1-22, The Arcade, 14 & 16, Corporation Street, 23 & 25, Market Place, Dewsbury, WF13 1QG

Following my site visit at the Dewsbury Arcade I comment mainly in regards to fire safety as follows

DRAWING TITLE
Third Floor GA Plan as Proposed

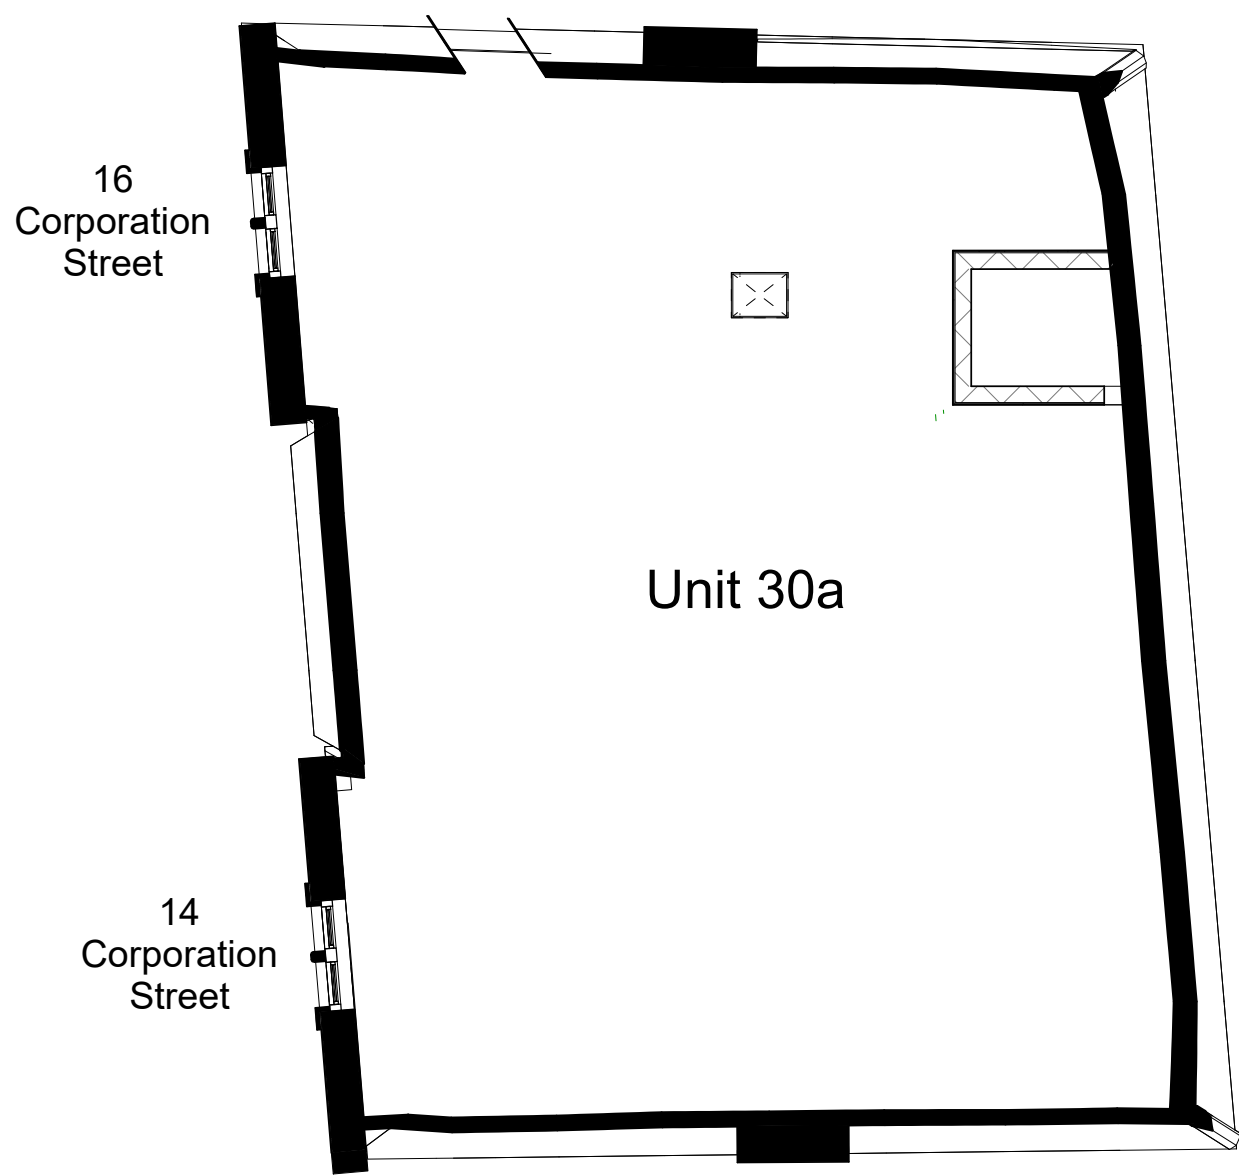
1. Means of Escape to the upper floors would not be acceptable in commercial premises due to
 - a) Inner Rooms to the first floor upwards
 - b) Staircase widths
 - c) Suggest to design out the existing problems with Means of Escape and to have a meeting on site with the Fire Service
 - d) Look at the fire risk for that building and involve Ian Swallow (Fire safety team manager) for a fire risk assessment
- 2 Consult with the Fire Service The main legislation is the Regulatory Reform (Fire Safety) Order 2005 or "the Fire Safety Order"
The responsible person for the premises is also required to:
 - a) Consider who may be especially at risk.
 - b) Eliminate or reduce the risk of fire as far as is reasonably practical.
 - c) Provide general fire precautions to deal with any risk
- 3 Consider The Equalities Act 2010
